FW: aw/262/25/pl

- 1459-01A – now showing the existing trees to the east of the building.
- 1459-02A – now showing the blue line boundary showing extent of adjoining ownership, and the location of the proposed bin store on the block plan.
- 1459-04A – now showing the existing trees to the east of the building and the position of the proposed bin store.

I am the officer on the application at AW/262/25/PL

REV	DESCRIPTION	DATE
	PROJECT FORMER PUBLIC WCS, MARINE PARK GARDENS, MARINE DRIVE WEST, BOGNOR REGIS PO21 2QS	
	CLIENT ARUN DISTRICT COUNCIL	
	DRAWING TITLE SITE LOCATION AND BLOCK PLANS	
SCALE	DRAWN BY	DATE
1:500 @ A3	SKW	SEPT '25
1:1250 @ A3		
DWG NO	1459/02	REV. -

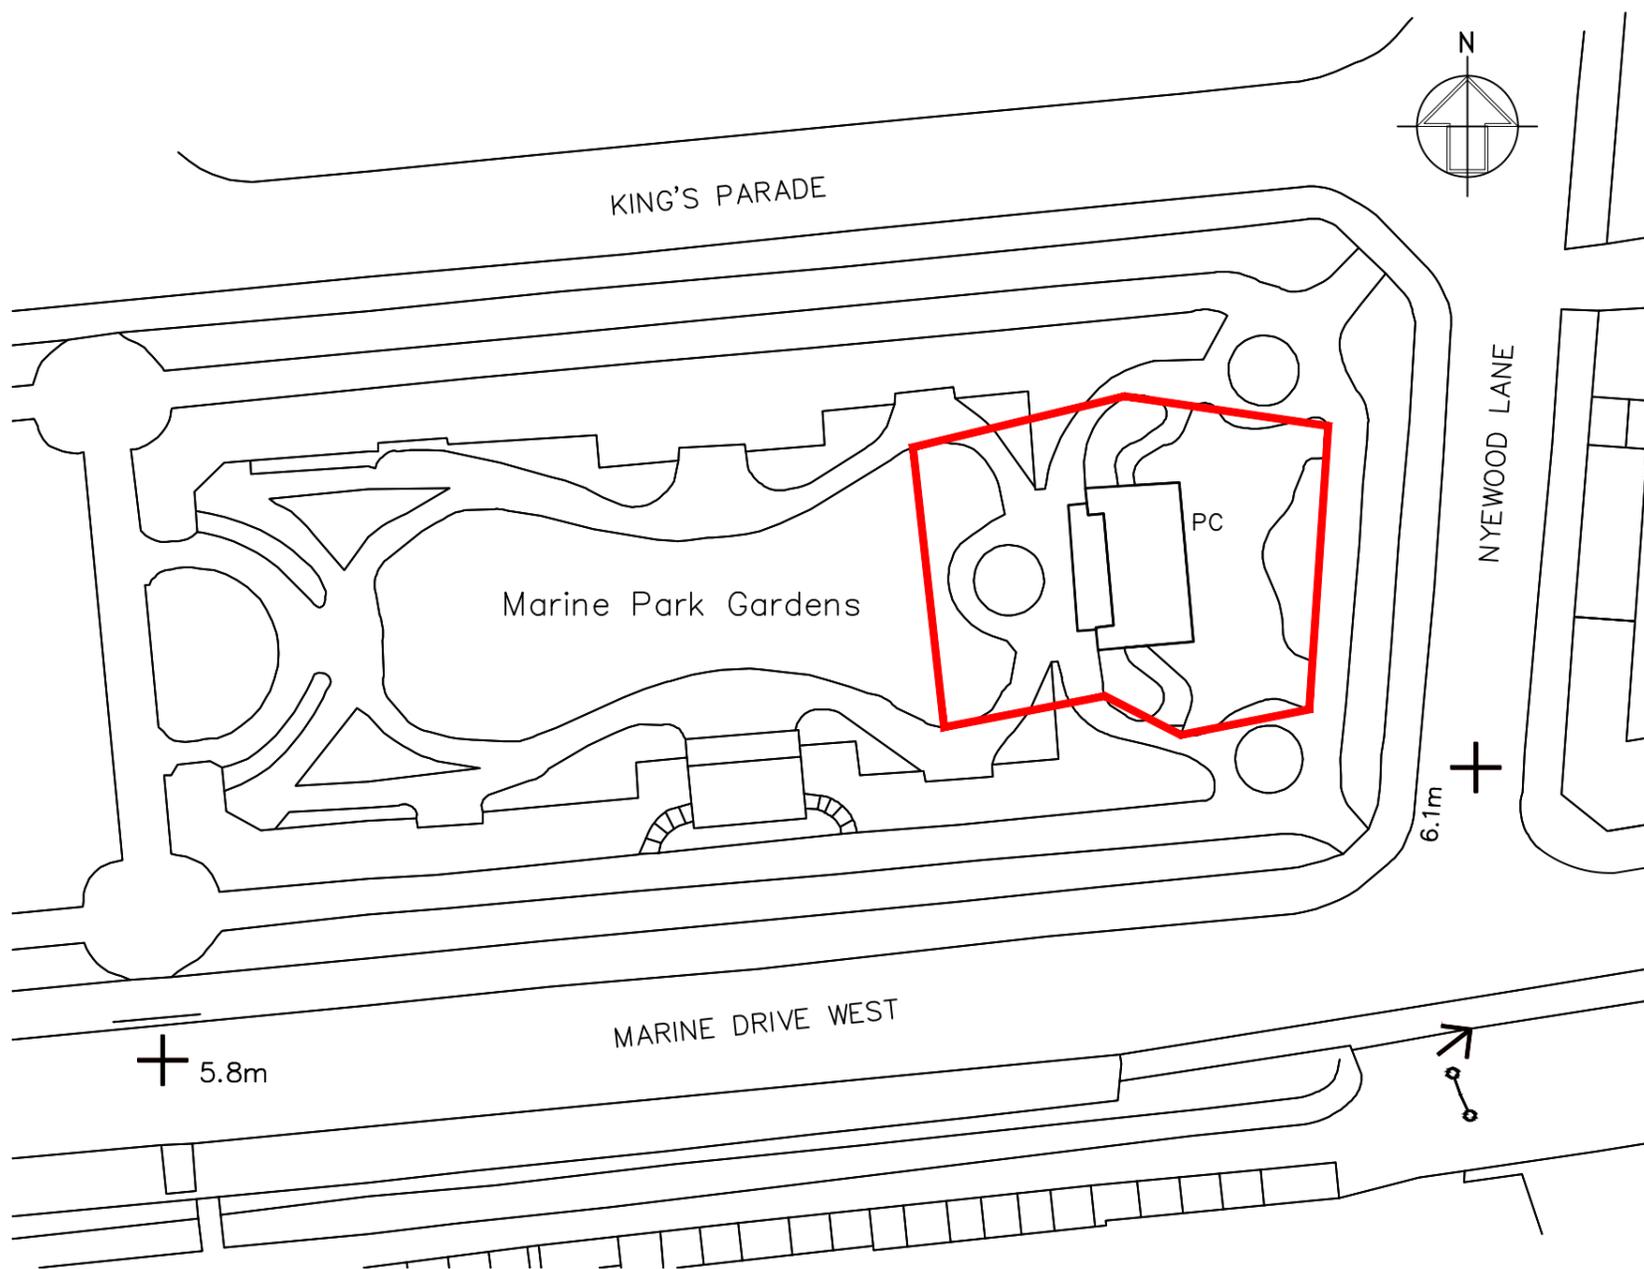
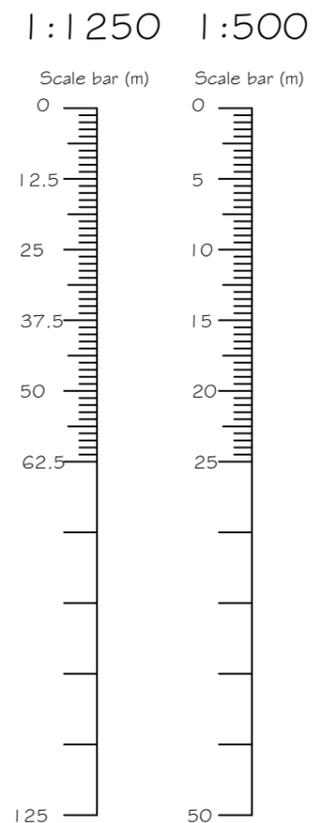
Please are you able to amend the location plan to blue edge the remaining site which is under ownership by the council. Also on the block plan please are you able to show where the bin store will be located.
